Rezoning Transportation Analysis

Petition Number: 2022-214

Revision Log:

Date	Description
05.24.2023	First Review (PDM)
06.21.2023	Second Review (DR)

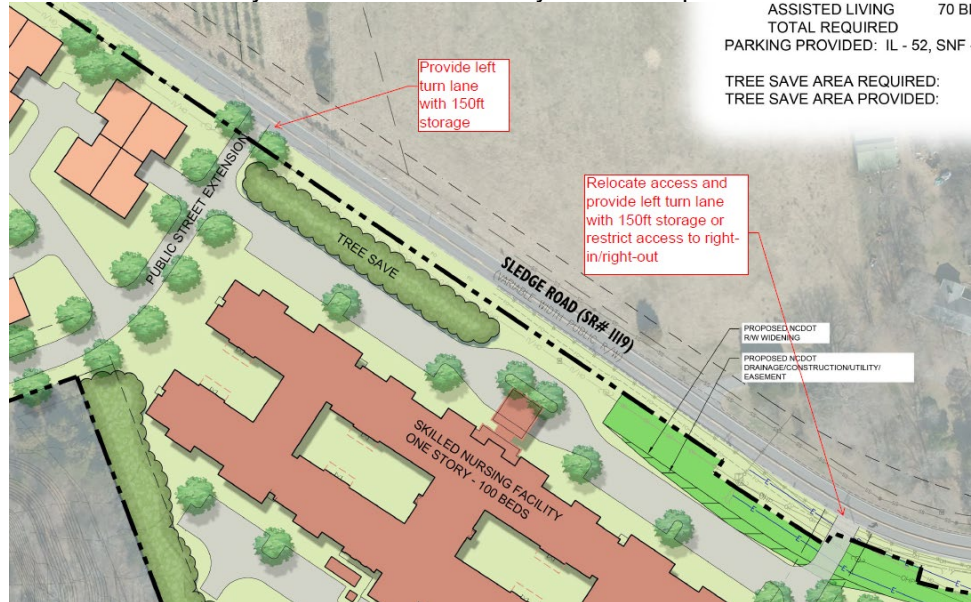
- ~~8. Per coordination with NCDOT provide turn lane and access management modifications per the markup below to meet NCDOT Policy on Street and Driveway Access requirements.~~
